From: Amanda Scholes on behalf of Planning.Responses
Sent: 01 June 2020 11:59
To: Planning Scanning
Subject: FW: *EXTERNAL: RE: BN/18/20/PL, Former Brooks Nursery

From: Paul Cann <Paul.Cann@arun.gov.uk>
Sent: 01 June 2020 09:38
To: Webster, Gary <[REDACTED]>; Maria Tomalova <Maria.Tomalova@arun.gov.uk>
Cc: Gateley, Jon <[REDACTED]>; Jones, Julian D <[REDACTED]>
Subject: RE: *EXTERNAL: RE: BN/18/20/PL, Former Brooks Nursery

In terms of the proposals effect on the existing suds (surface water drainage system), I would like to make the following comments;

| Title       |          | Foul Outfall Rising Main Details            |          |

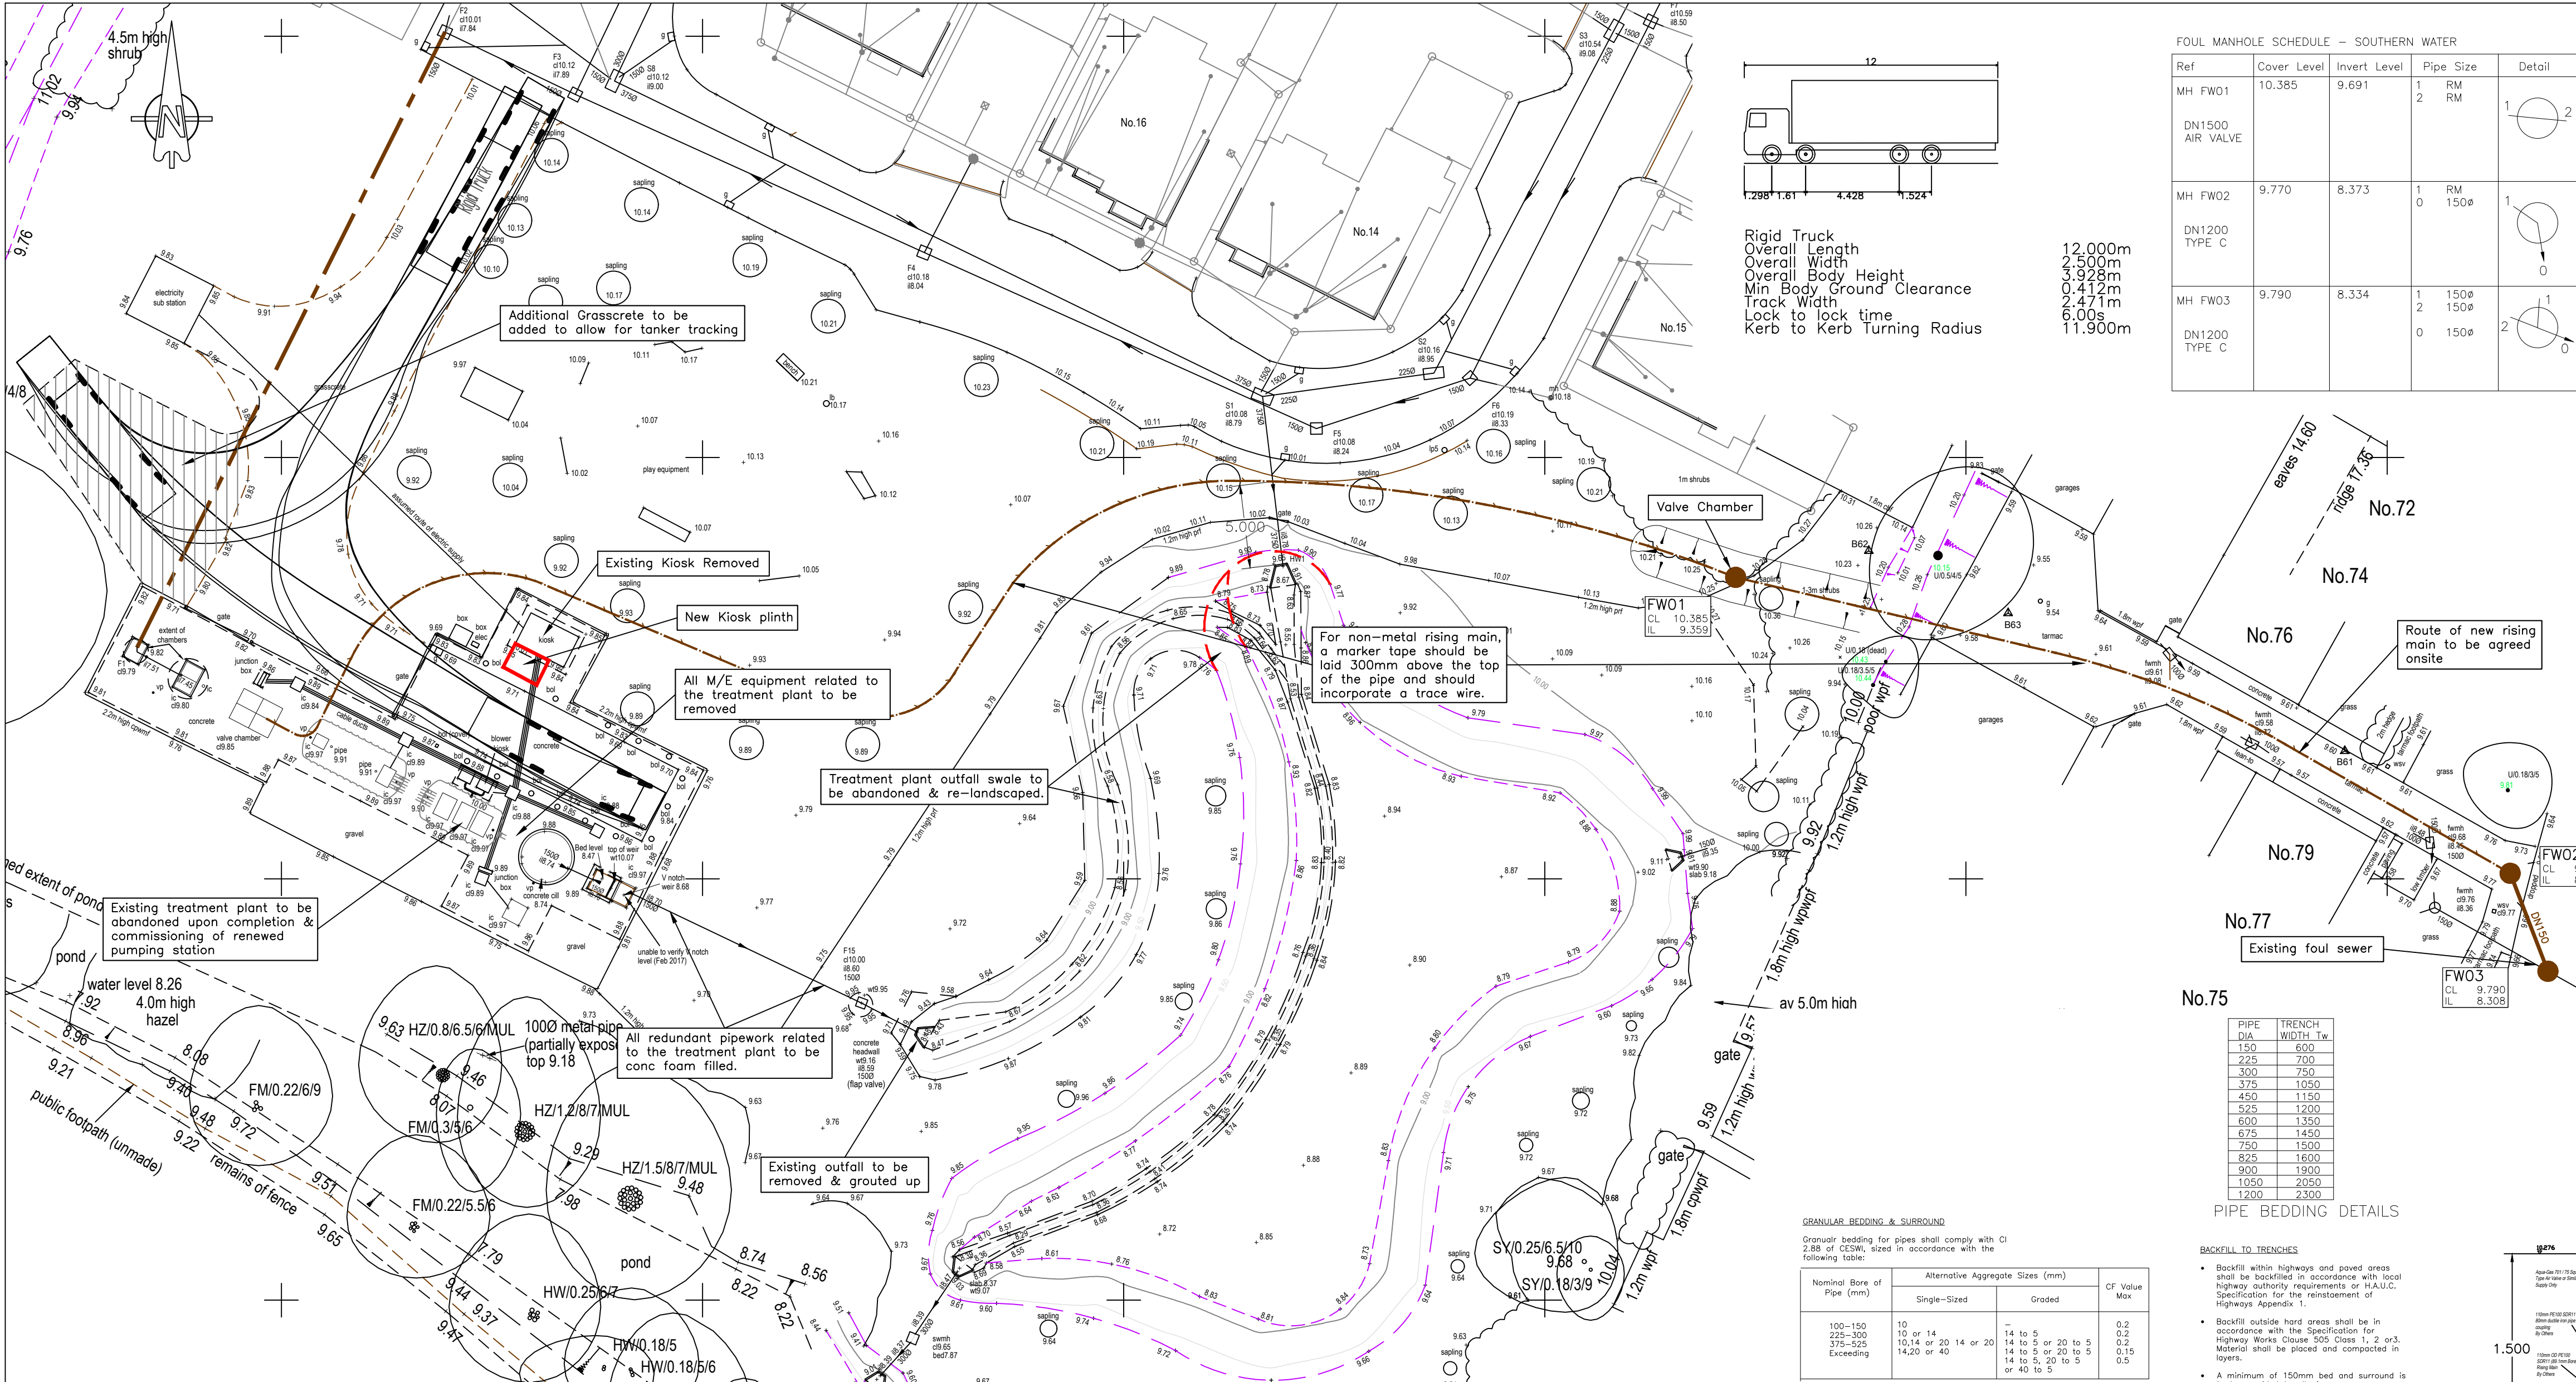
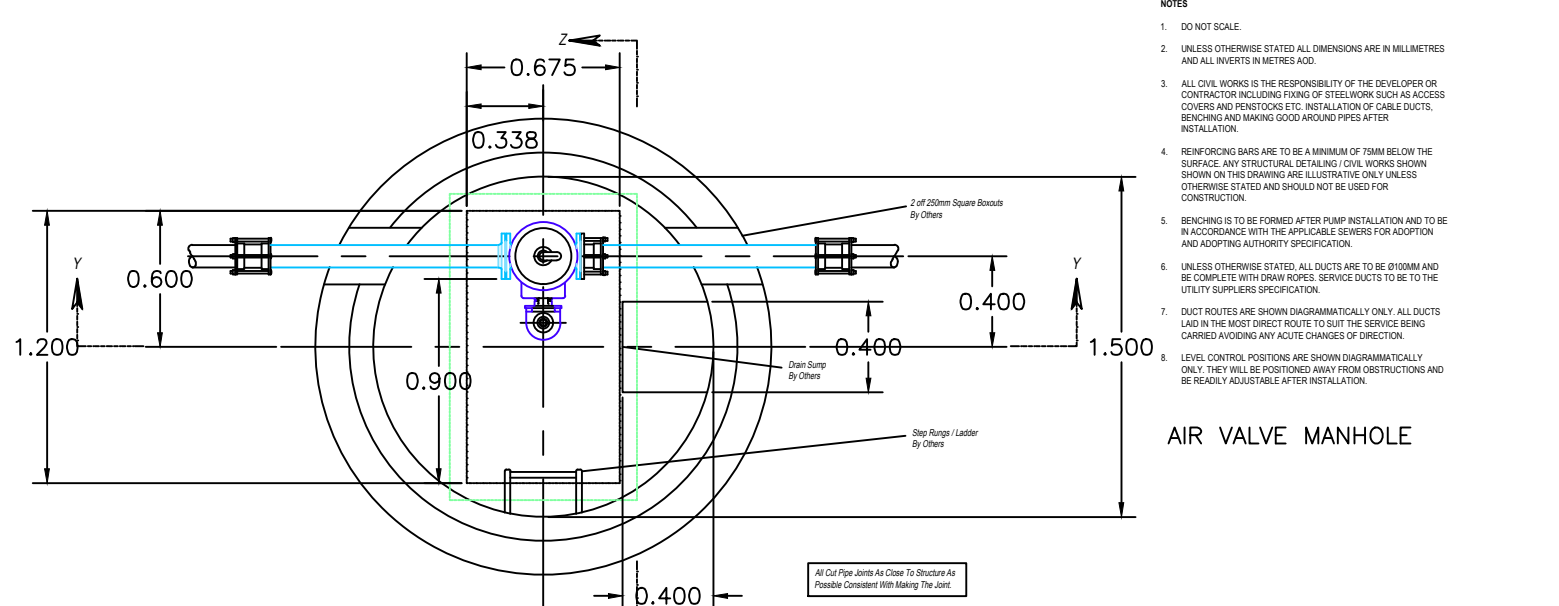
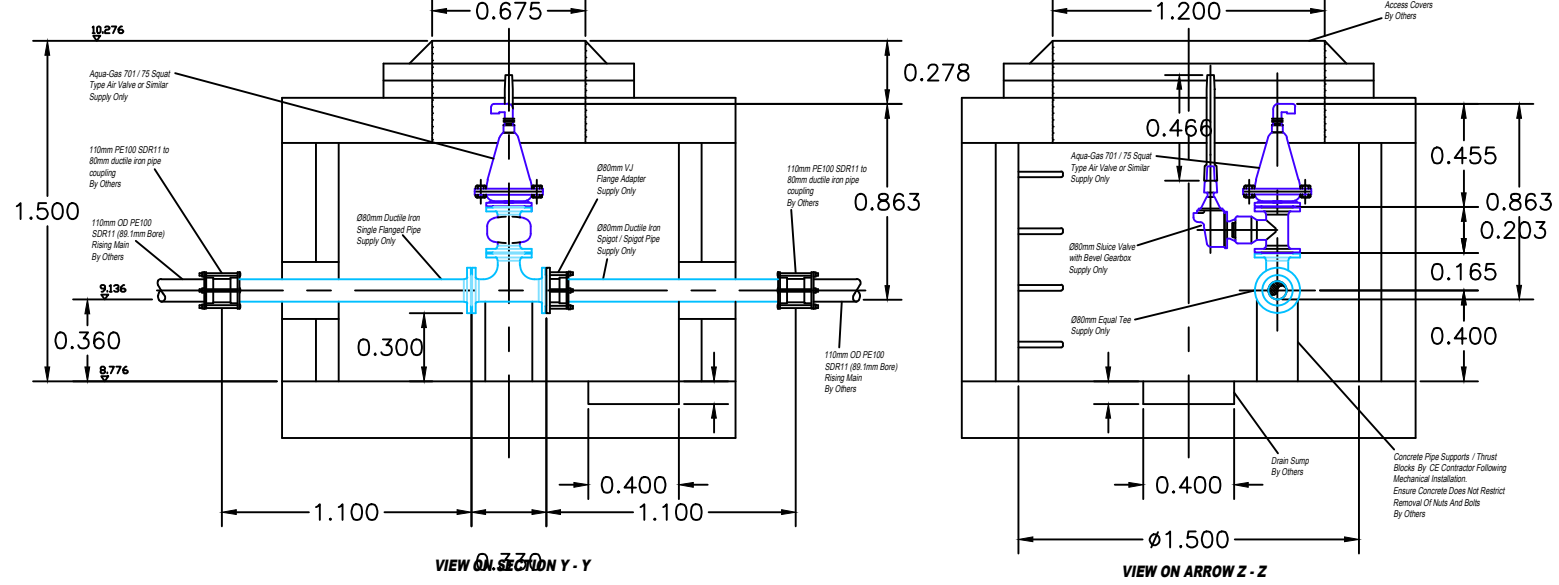
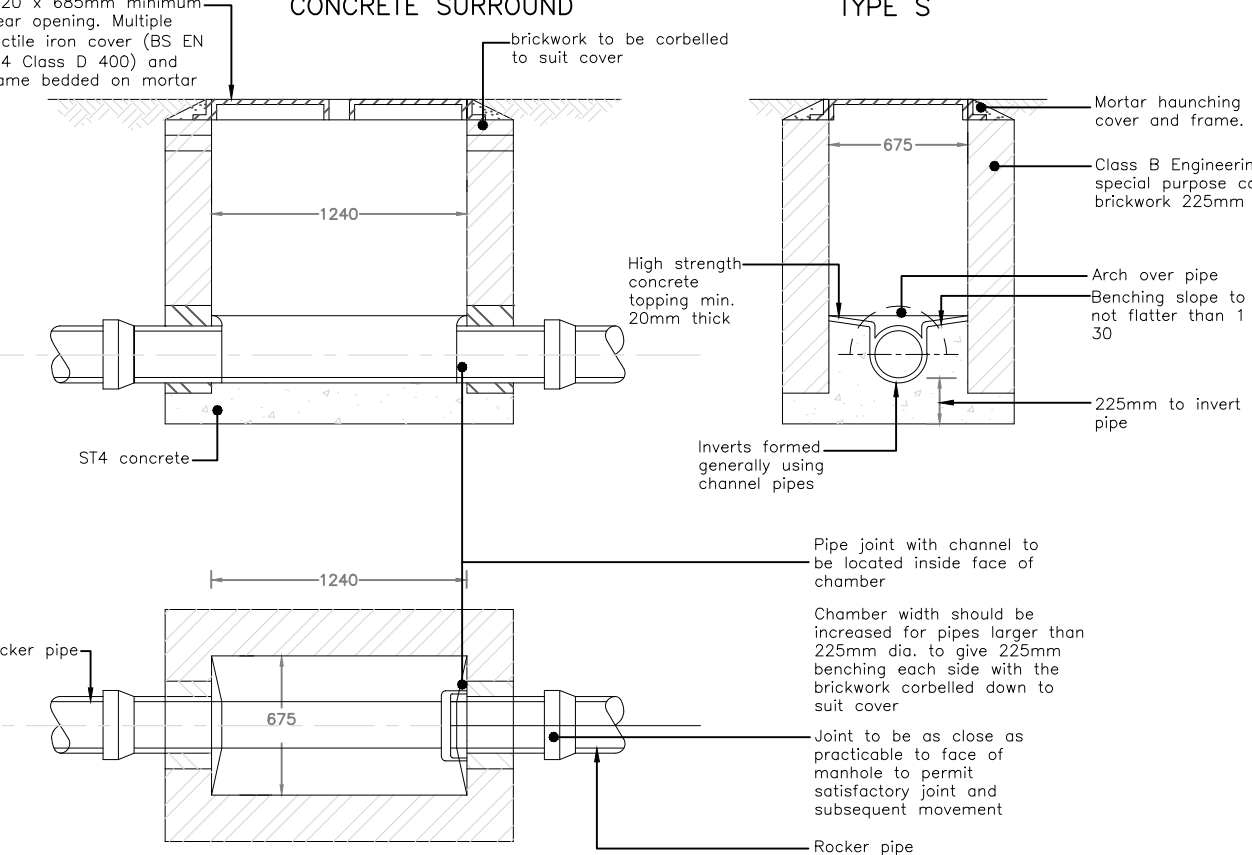
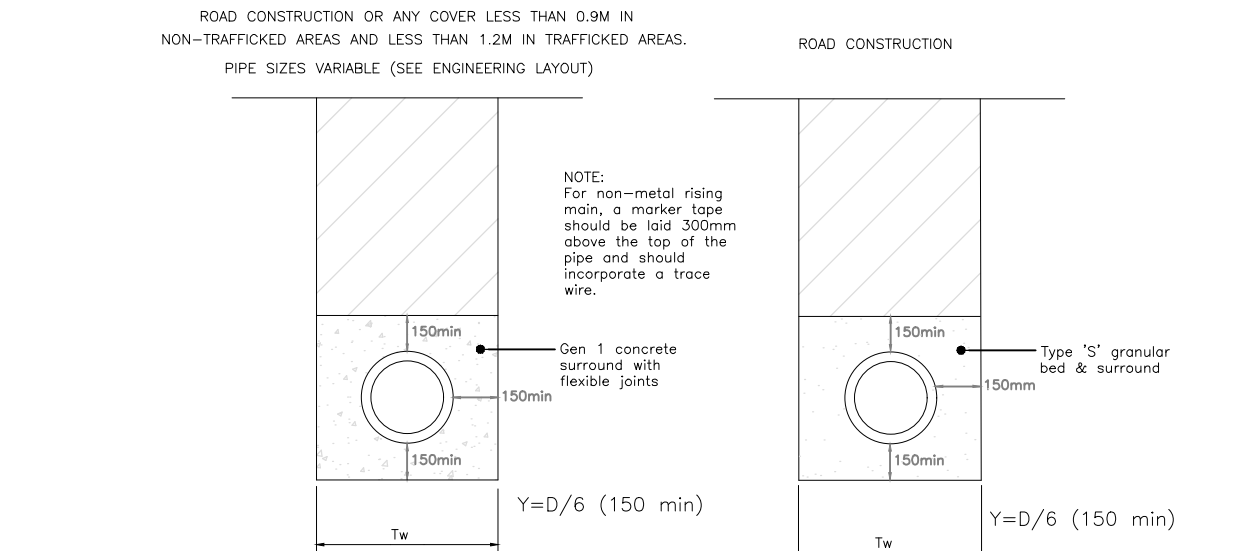
Contents noted. I await the revised long section.

- The small outfall ditch for the treatment plant was not part of and did not contribute to the overall volume within the surface water attenuation design, this was purely an outfall for the foul treatment plant. By not filling the ditch in would potentially create a dead stagnant spot for water, as this won't be part of the natural flow path. The original pond calculations are attached for clarity. Noted but calcs not included in email.
- The rising main section previously submitted was updated following discussion with Southern Water, however this was regarding the off-site connection and some manhole details. Nothing has changed regarding the rising main position over the existing surface water outfall pipe. The longitudinal section needs to show the land drain on the eastern boundary to make sure there is no clash with the rising main.

- a) The open channel/ditch in which the sewage treatment plant discharges into at present, before it connects into the suds pond, is proposed to be infilled.
The applicant will need to be provide written confirmation with supporting calculations to prove that the storage for surface water within the suds system is not compromised as a result.
- b) Where the proposed rising crosses the incoming surface water outfall to the pond and the known land drain running parallel to the eastern boundary of the development, the applicant should provide a longitudinal section to prove no impact on these pipelines.

I will ask our engineer for the long section to incorporate the land drain requested

Finally, the long section requested was already shown on drawing no, 4482.510A , which I attach for reference along with the other engineers drawings which were agreed at the meeting
